Application No: 19/00213/DISC

Proposal: Discharge of conditions 6 (new link road), 8 (surface water drainage), 9 (floor levels), 10 (play areas), 11 (arboricultural survey), 12 (ecology), 13 (secured by design), 14 (contamination), 18 (mitigation for badgers) and 35 (cycle lanes) of 15/01326/OUT

Location: OS Parcels 6741 And 5426 West Of Cricket Field Nor Wykham Lane Bodicote

Transport Development Control

Drawing file: 957-02-01 Rev A Bus Strategy.pdf

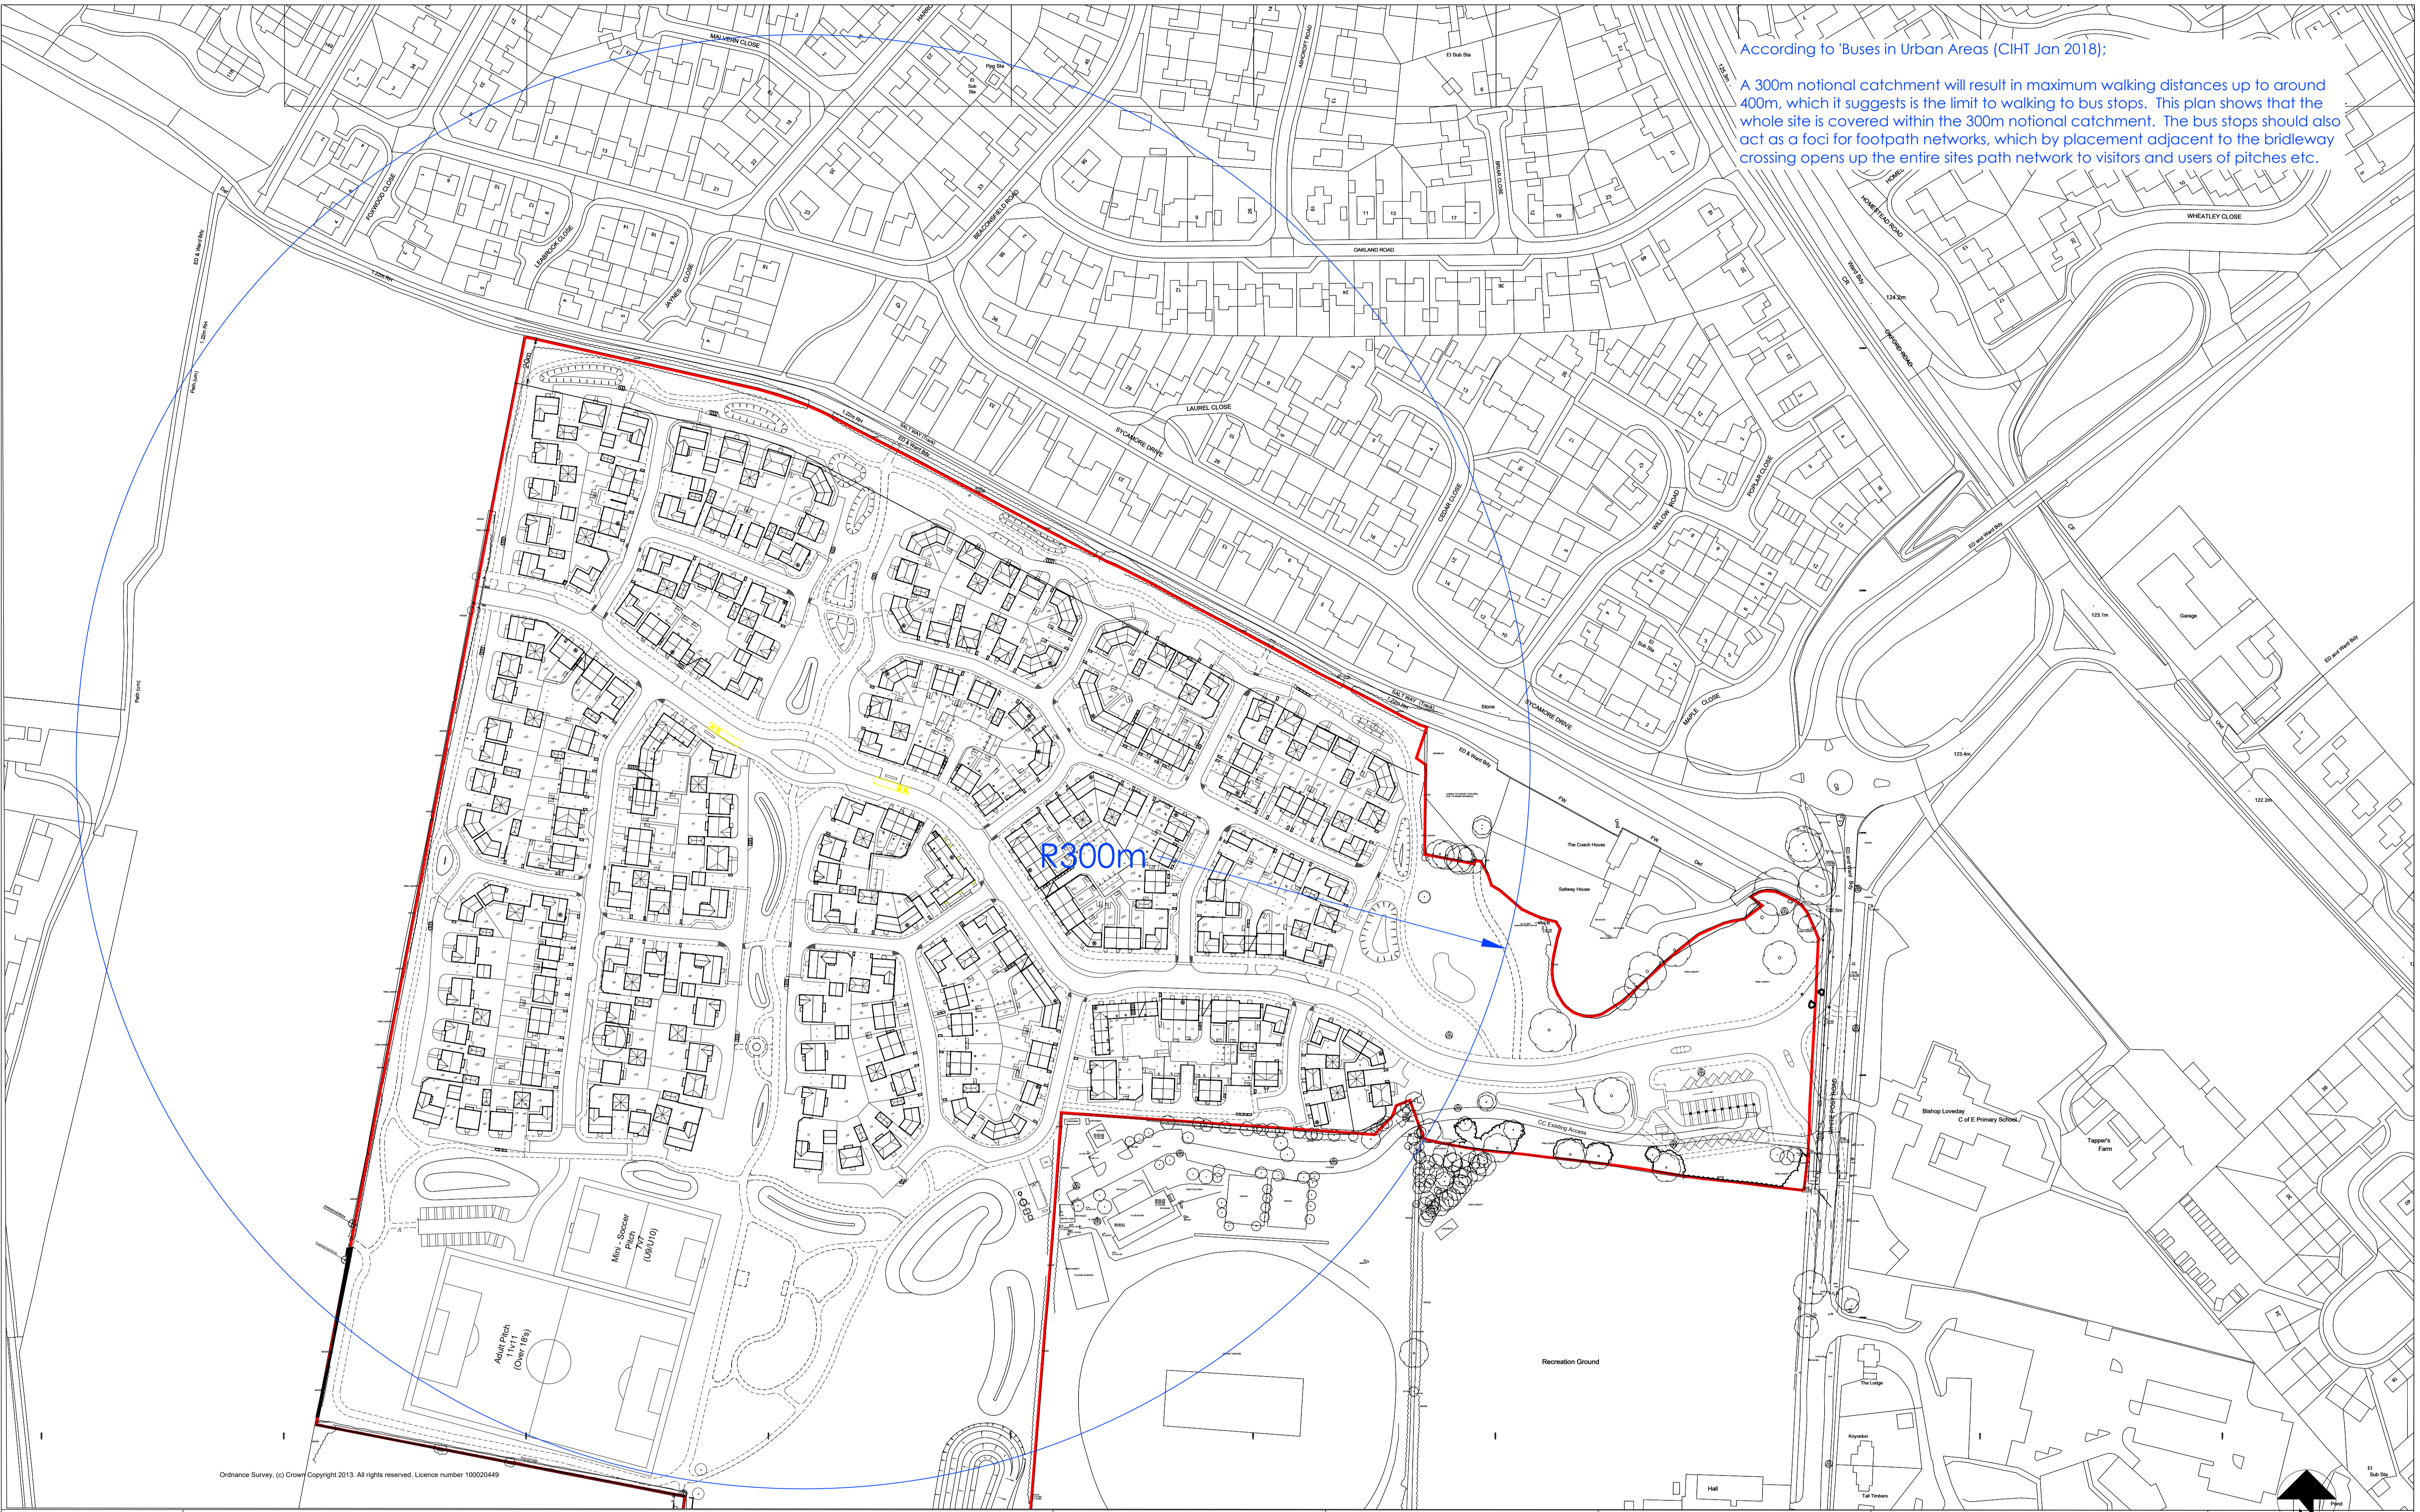
The UU provided contributions for two pairs of bus stops within the site. Only one pair of stops is shown here. It was suggested in preapp advice that a second pair could be positioned near the open space at the eastern end.

Additional hardstanding space has not been shown for bus shelters – this must be provided for the eastbound direction. Shelters must not overhang the shared use ped/cycle route.
